From: Dewi Parry [REDACTED]
Sent: 08 December 2015 22:14
To: North Wales Wind Farm Connection
Cc: eifionbibby@dmpropertyconsultants.com
Subject: Option A/B preference

On inspecting the Option A/B comparison plans in detail following the hearing (Plans CP1-CP5, Sheet) and having checked the Applicant's response to ExA 2ndQs submissions, Deadline 7 (REP7-005) there appears to be an error in the Applicant's description of pole positions. I appreciate that the Examiners need a timely response and I apologise for not having spotted this sooner but this uncertainty about the Applicant's description makes it difficult for us to reach a preference as it relates to visual screening issues. The passage in question is on page 14 of REP7-005 : "Pole 65 will shift by approximately 4m to the southwest of its original Option A location and will sit slightly lower in the landscape."

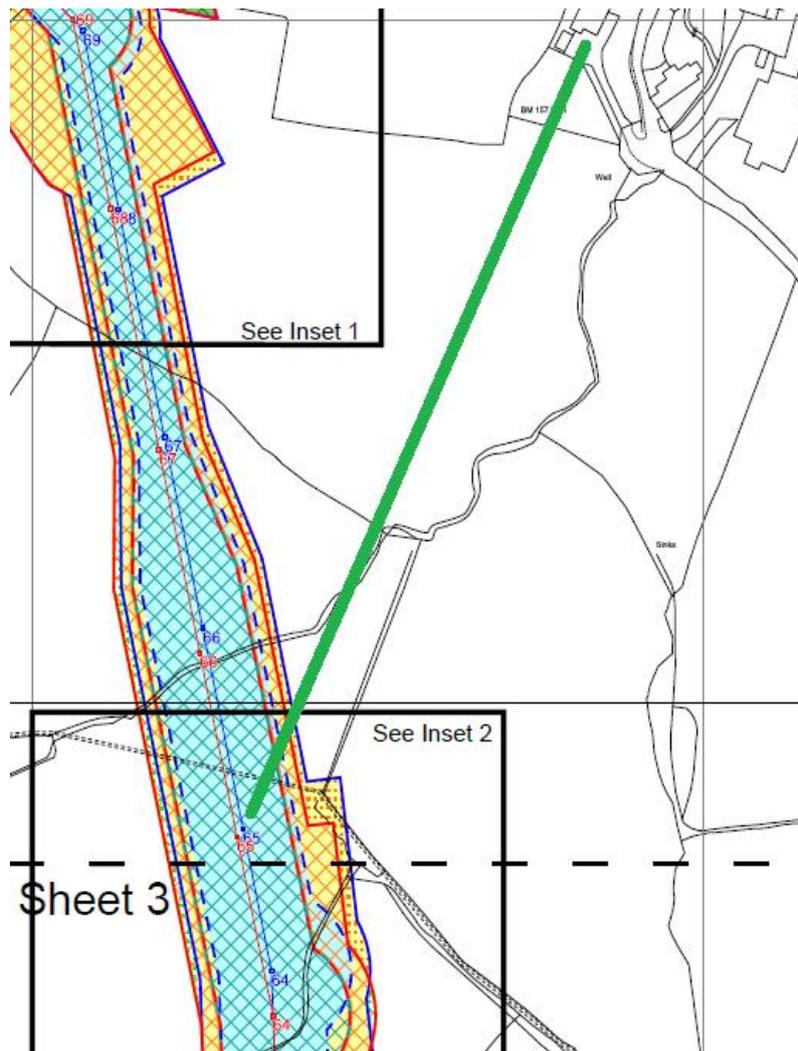
In looking at the plans and knowing the landform I believe the correct description should in fact be: "*Pole 65 will shift by approximately 4m to the southeast of its original Option A location and sit slightly higher in the landscape*".

It's an important point because a shift in Pole 65 position could mean that it may no longer be screened by two intervening mature trees. If my description is the correct one it's more likely that visual screening of Pole 65 would be lost for residential receptors, which may possibly make Option A the more favourable.
